27 June 2023

Application by London Luton Airport Limited for an Order Granting Development Consent for the London Luton Airport Expansion project

Procedural Decision made under Section 89(3)

Table 1 - The Applicant's response to the Rule 9 Procedural Decision dated 16 May 2023

Figure A1.1: Indicative noise contour plan

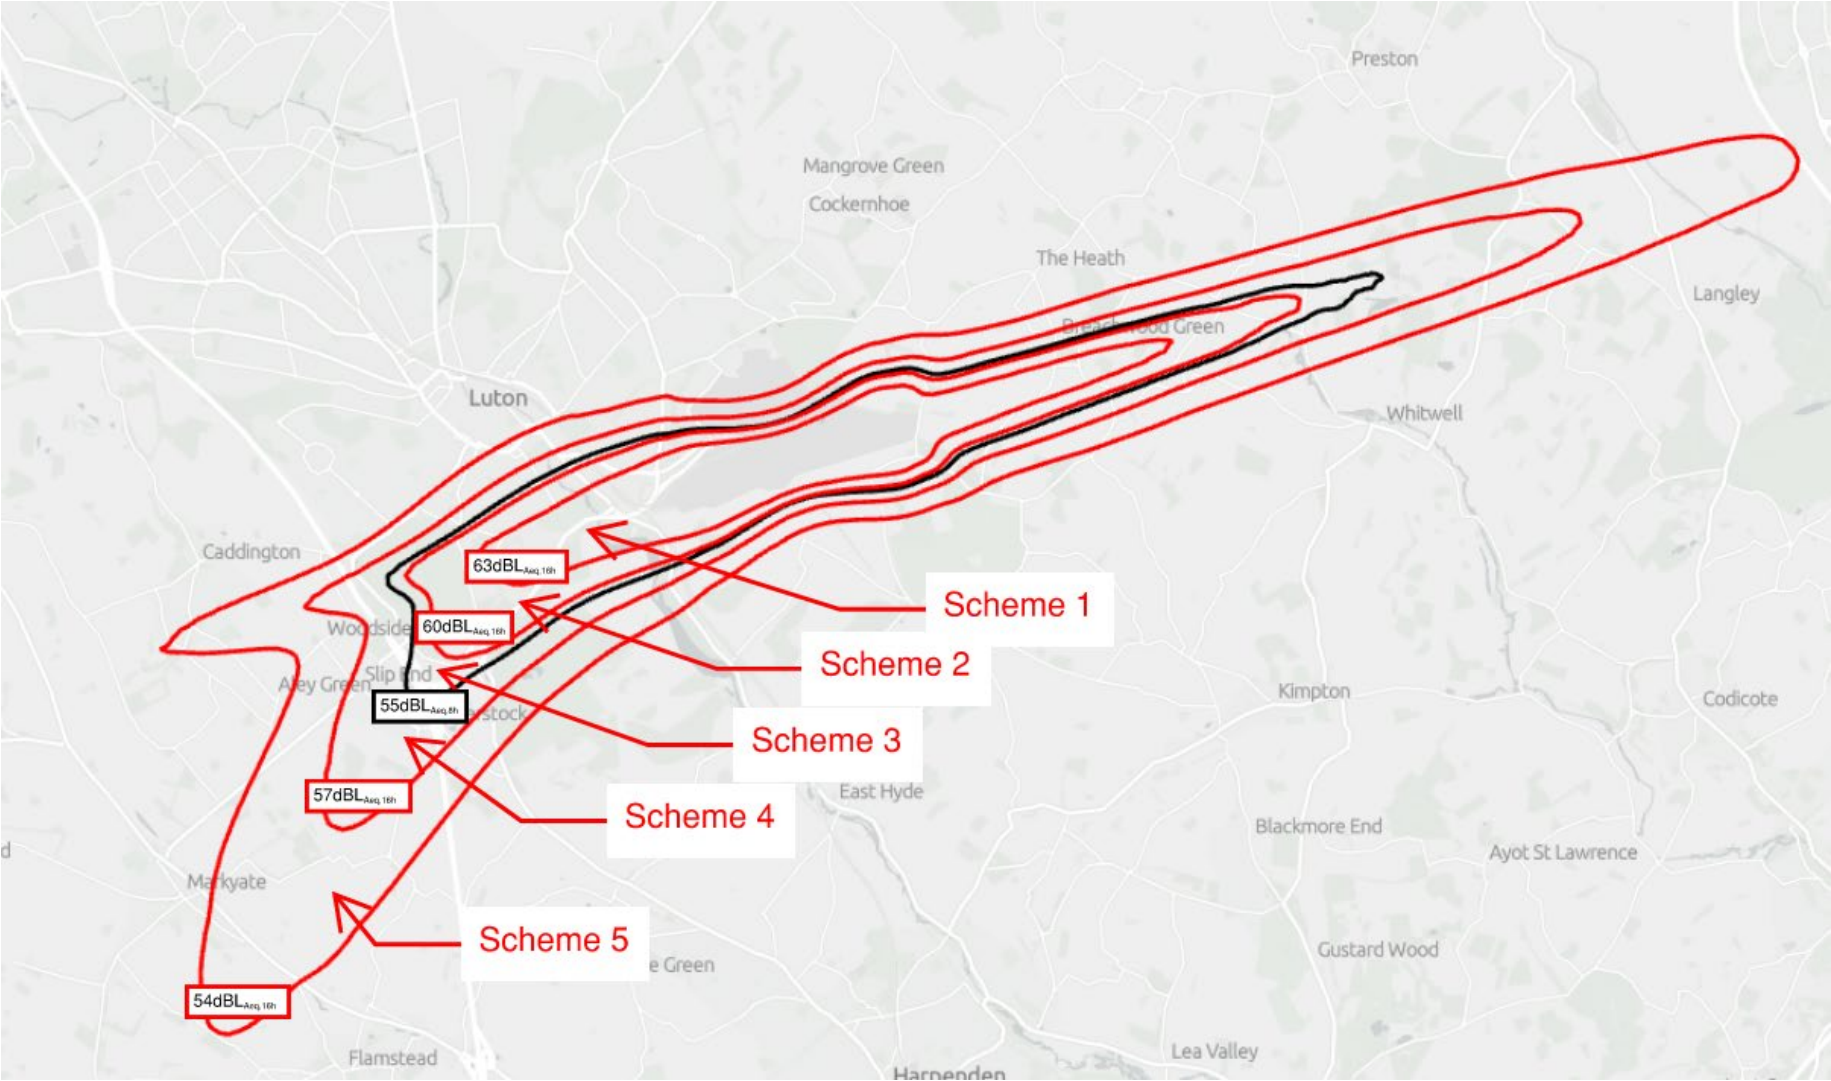
30b	AS-050	Draft Compensation Policies, Measures and Community First	Appendix A contains an Indicative Noise Contour plan. Provide a copy of the plan at A3 with a 1:50,000 Ordnance Survey Landranger background for each assessment phase and provide a second set of plans with the current eligibility contours overlaid on the new contours in a different colour.	<p>Figures have been added to the document with a 1:50,000 OS base map as requested.</p> <p>Figures A1.1 to A1.3 are provided in Appendix A Part 1 and present indicative plans representing the potential extent of the proposed noise insulation schemes using the forecast noise contours from Chapter 16 Noise and Vibration of the ES [TR020001/APP/5.01].</p> <p>A second set of indicative plans (Figures A1.4 to</p>

<p>A1.9) are provided in Appendix A Part 2, showing the potential extent of the proposed noise insulation schemes overlaid with the extent of the current noise insulation schemes. Due to the number of different schemes (current and proposed), this second set of plans has been separated by daytime and night-time.</p> <p>As these plans are for indicative purposes only, and are based on forecast noise contours, inclusion within the boundary of the plans does not definitively mean that a property would be eligible for noise insulation under the proposed scheme. Similarly, being outside of the boundary of the plan does not definitely mean that a property would not be eligible.</p>
--	--	--	--	--
